FROM: Marge Schmuckal, Zoning Administrator

SUBJECT: Site Plan Review for 746 Stevens Ave., UNE, Westbrook College
145 B-42 - R-5 Zone

DATE: November 16, 2000

FIRST FLOOR PLAN  
 L-A1

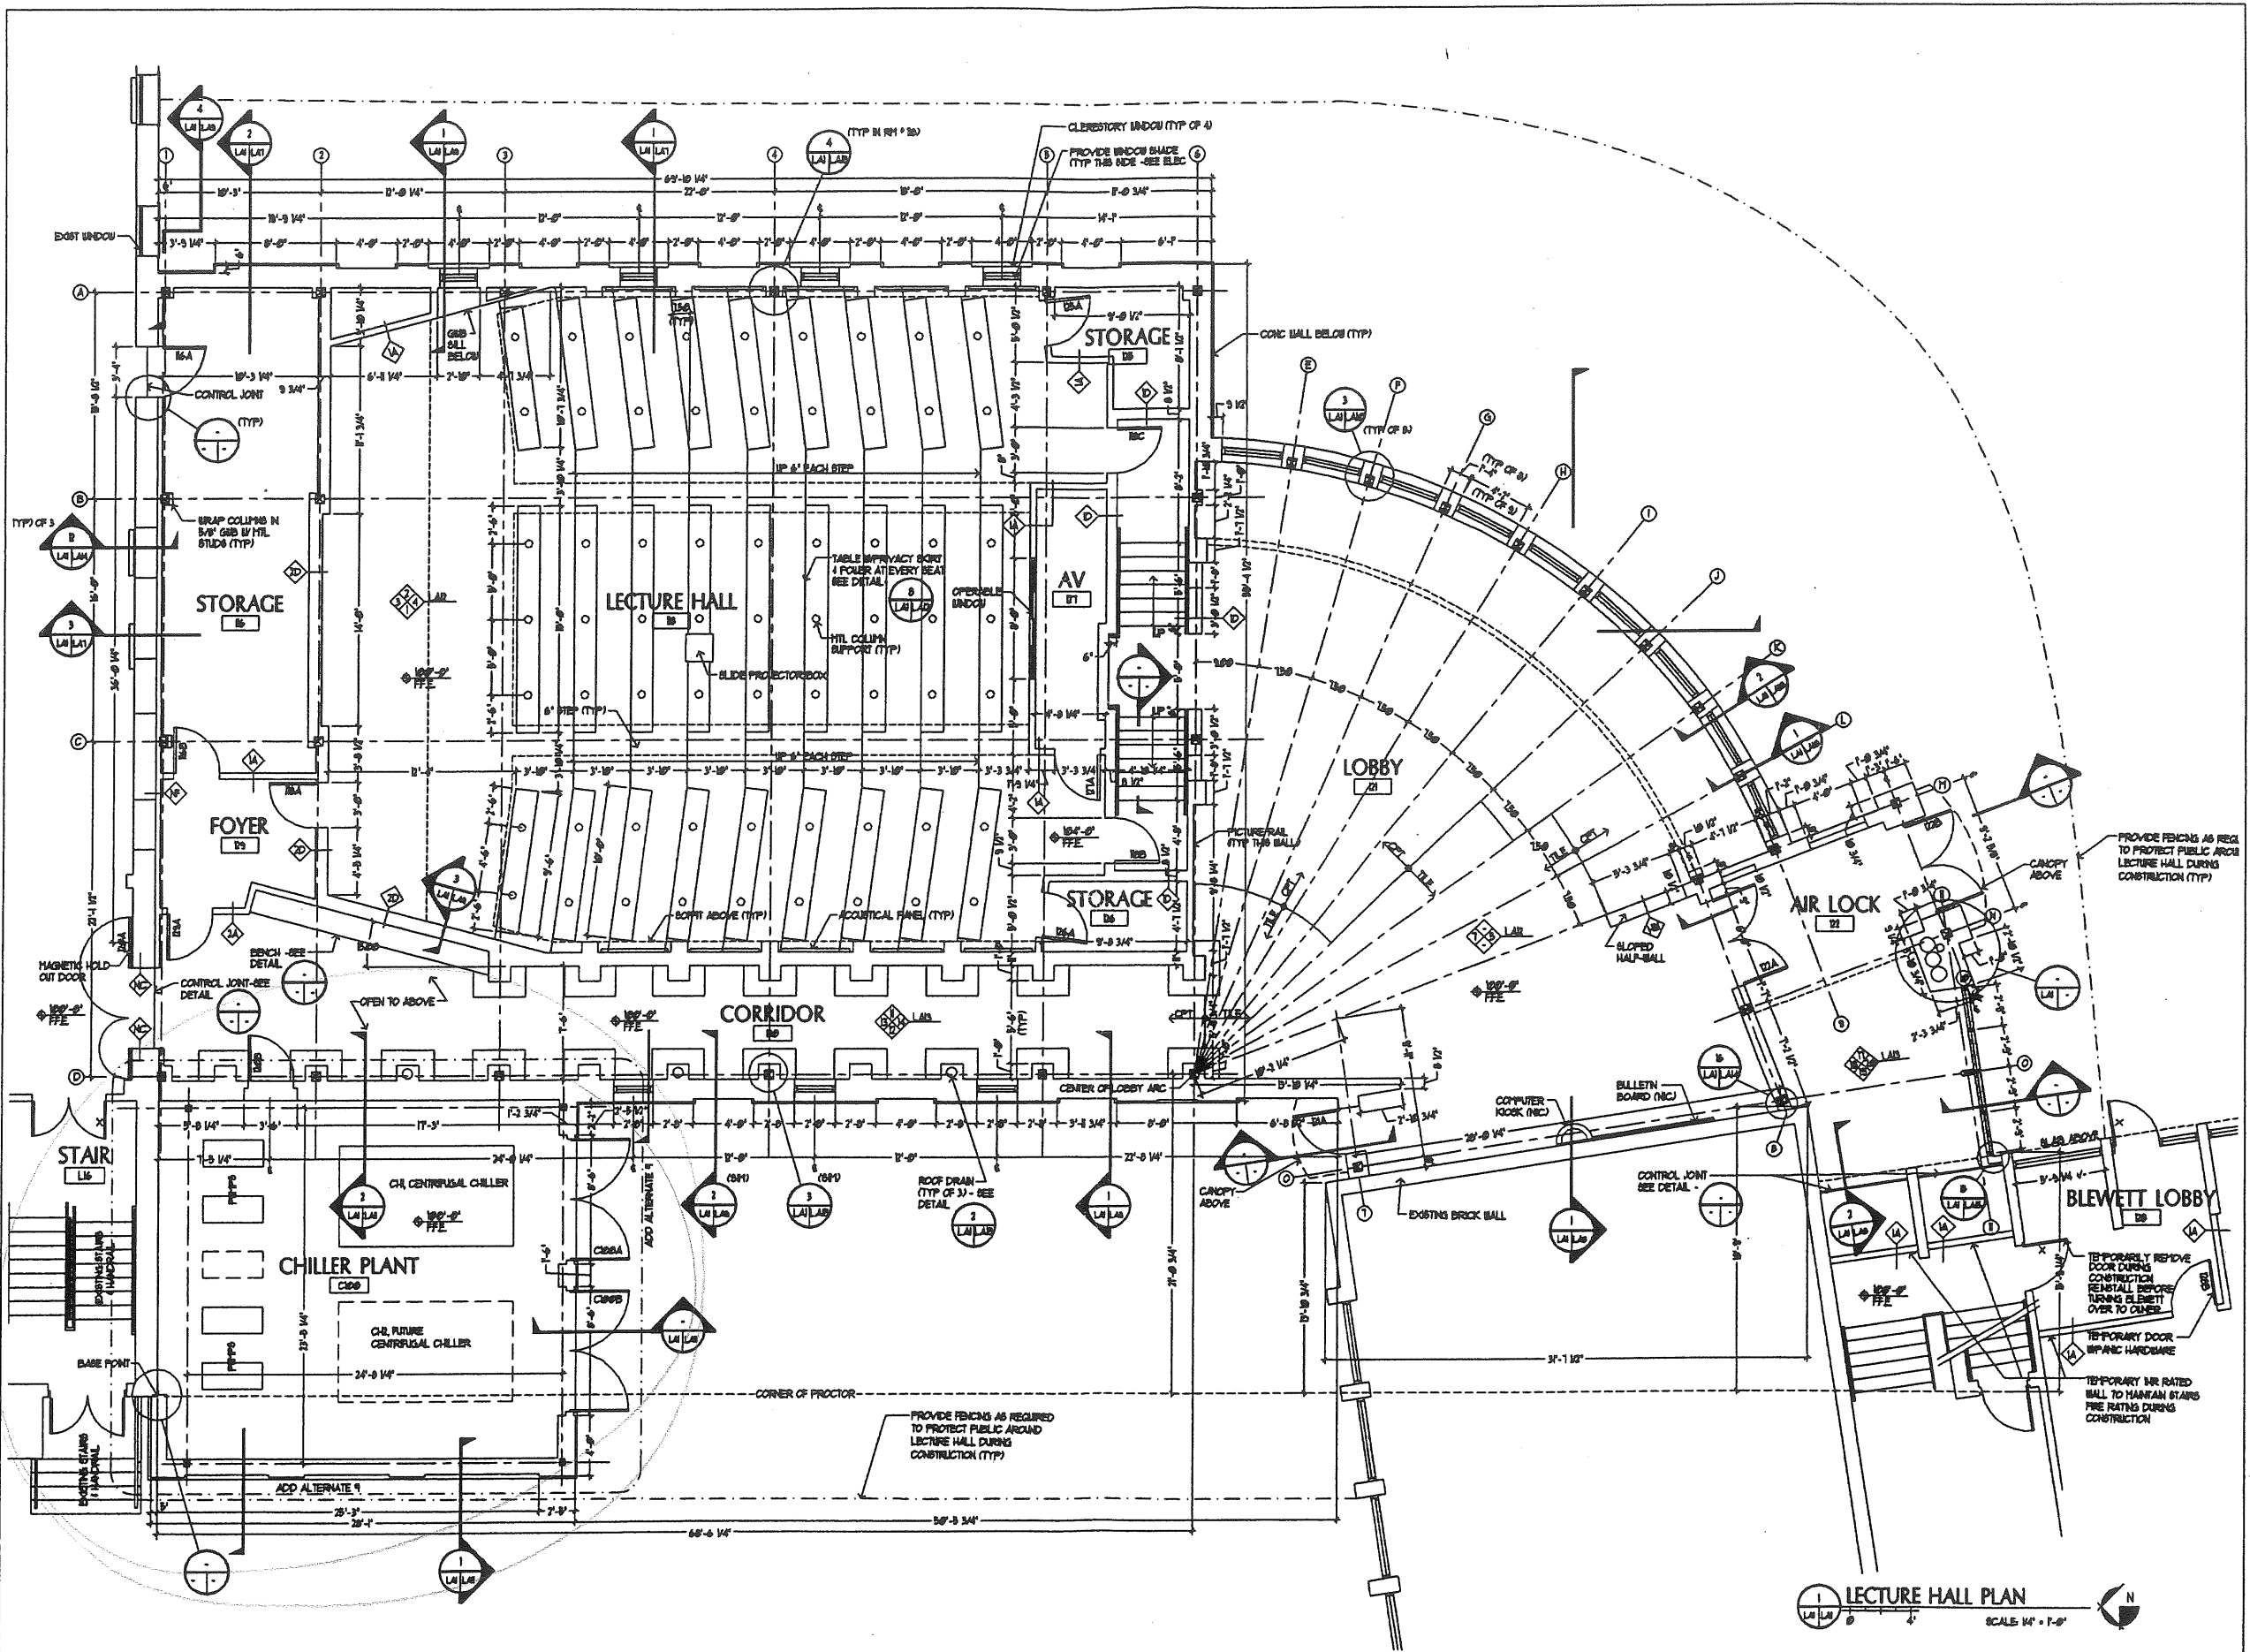
The new lecture hall meets the R-5 zone setbacks. It is a one story structure with the closest abutting neighbor being the Evergreen Cemetery. With Stevens Avenue considered the front of this campus lot, there is only an 8 foot required side setback.. The closest side property line is approximately 122 feet away. All setbacks have been satisfactorily met.

OVERALL  
SITE  
PLAN

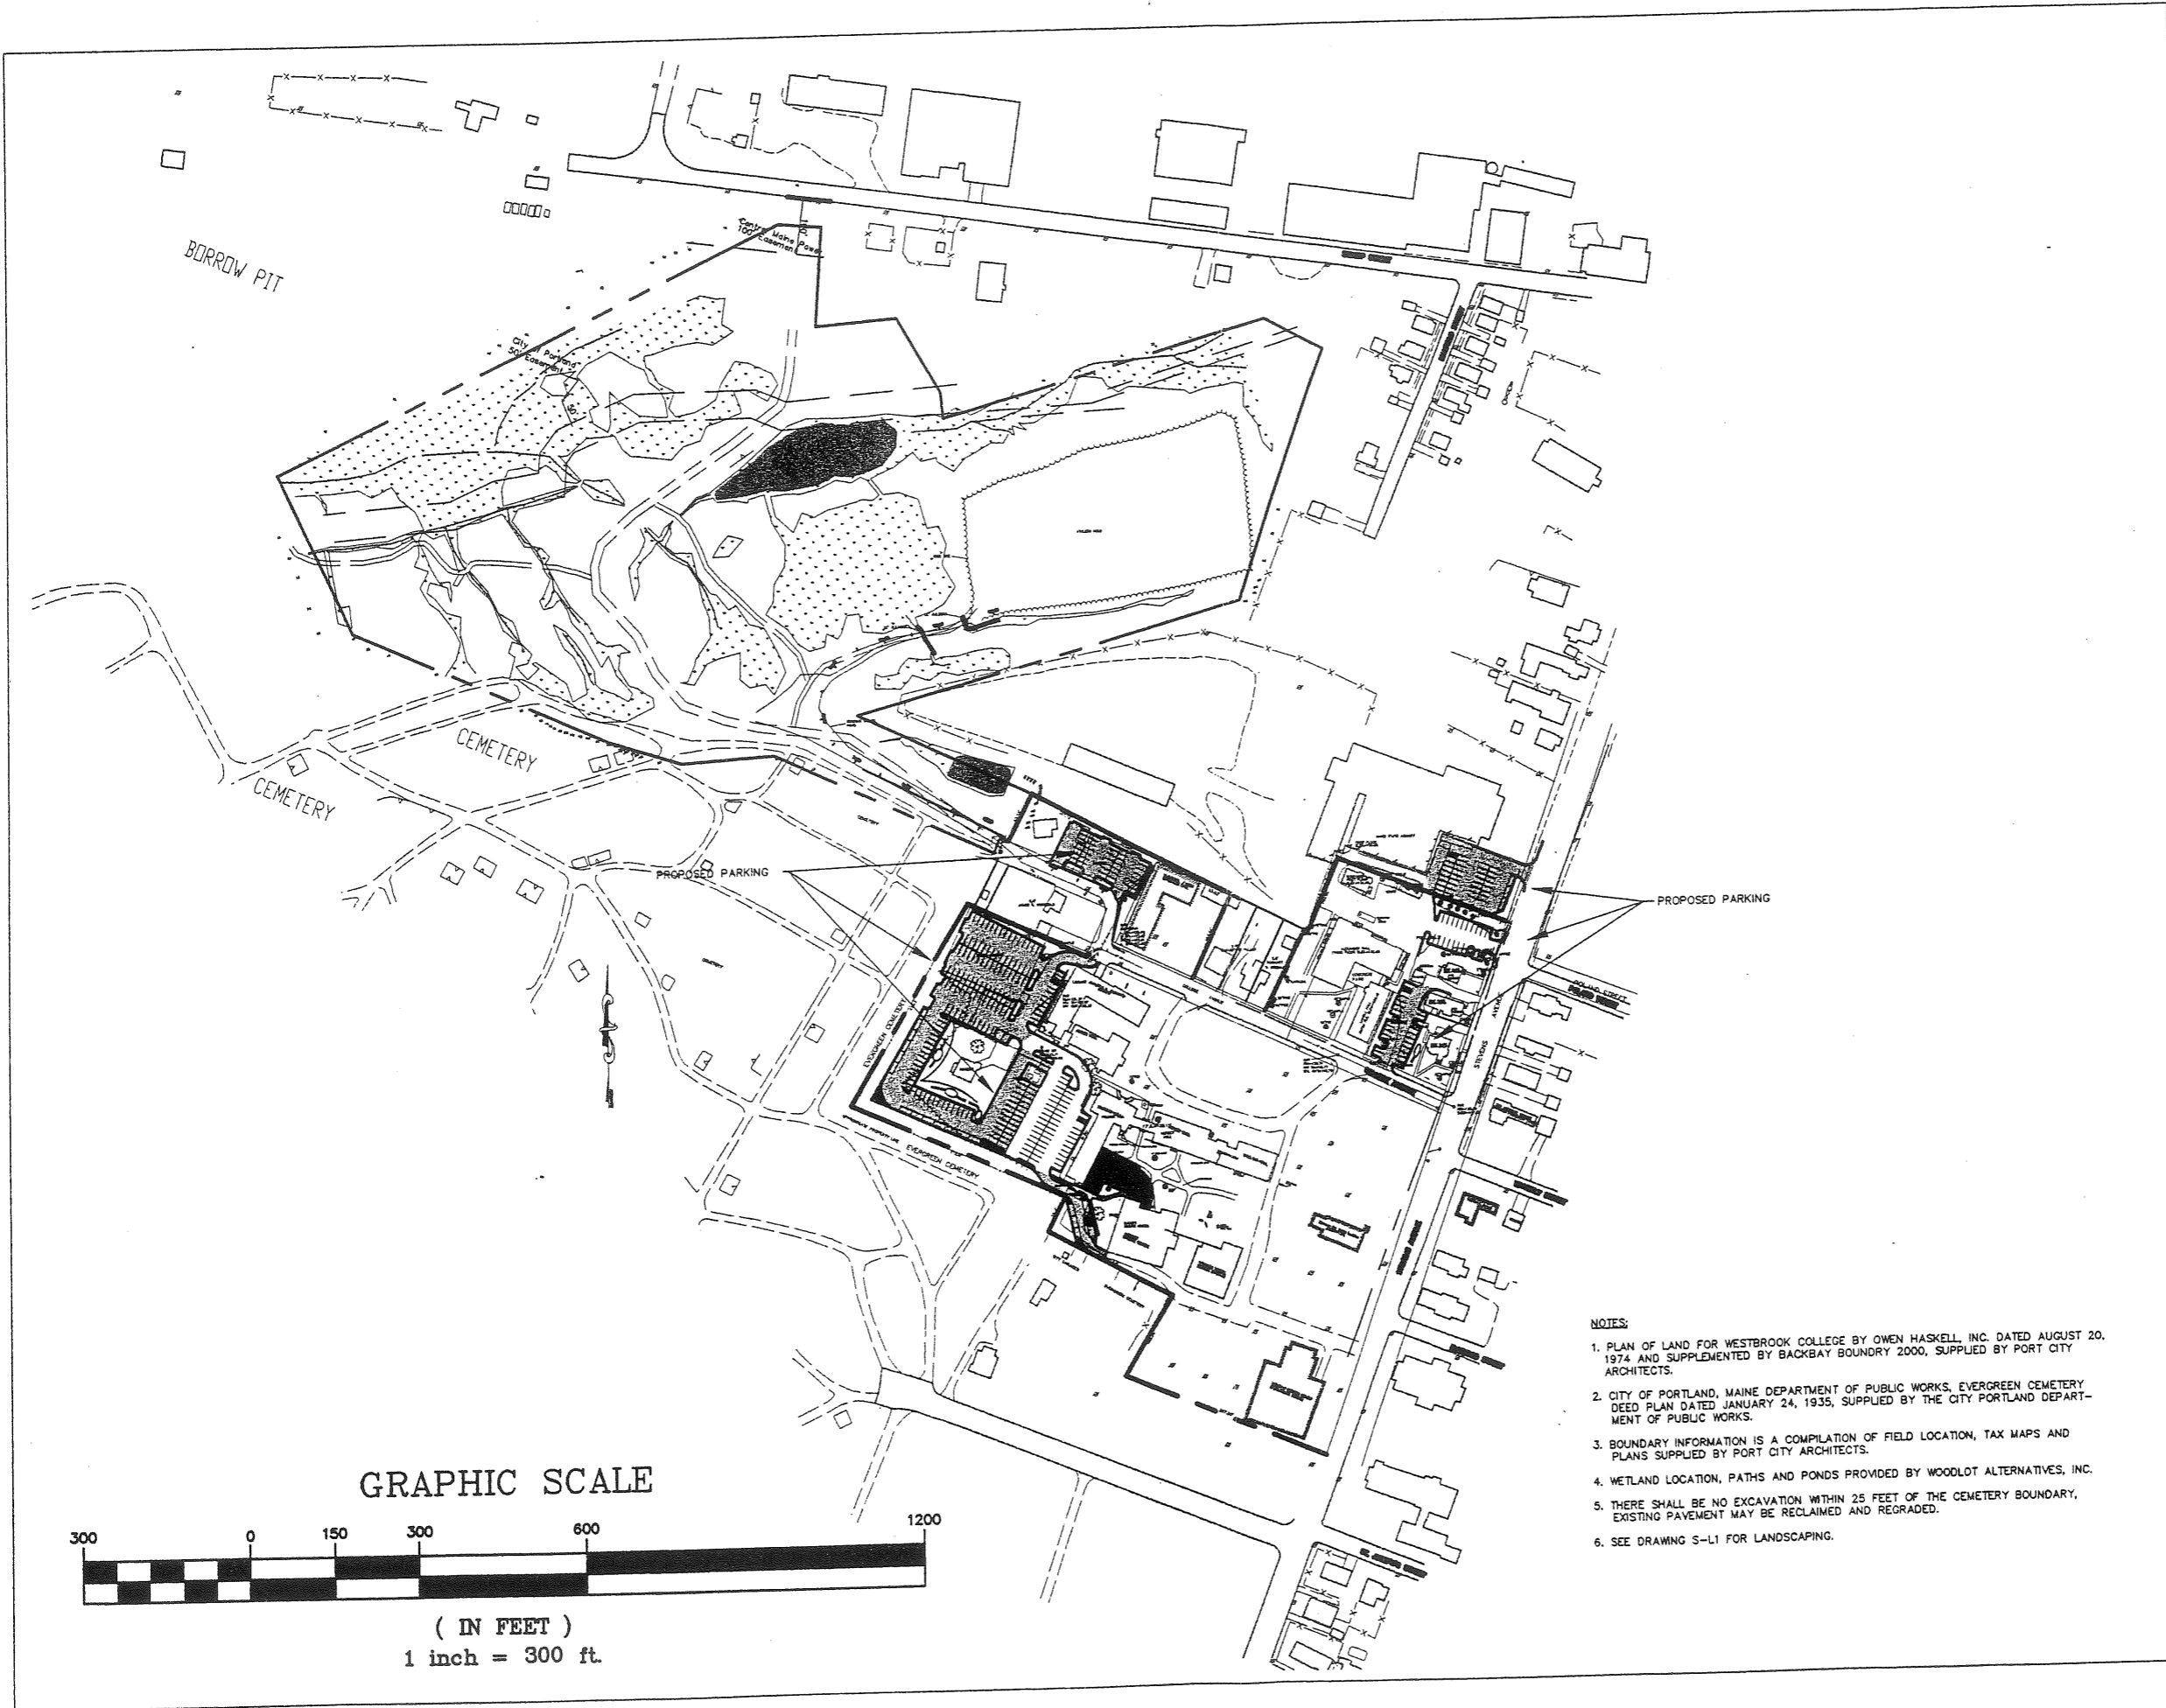
Parking setbacks have also been met. Please note that section 14-336 does not apply to parking lots for over six vehicles. However, section 14-337 states. "Where off-street parking for more than six vehicles is required or provided for nonresidential uses in residence zones, it shall not be located closer than 25 feet to any residential structure on an adjoining lot." I have interpreted that to mean actual lived-in residential structure. I do not believe that this section is meant to encompass accessory structures such as sheds or garages that are not living spaces. The closest residential structure to a proposed parking lot, is the McDonald property. The closest portion of the house is approximately 57 feet from the parking spaces, and therefore complies with the ordinance.

These parking lots shall also meet the requirements of section 14-340 entitled, "Construction requirements when more than six vehicles parked." I believe that this section of the ordinance will more than be met with all the other planning and public works design standards and requirements.
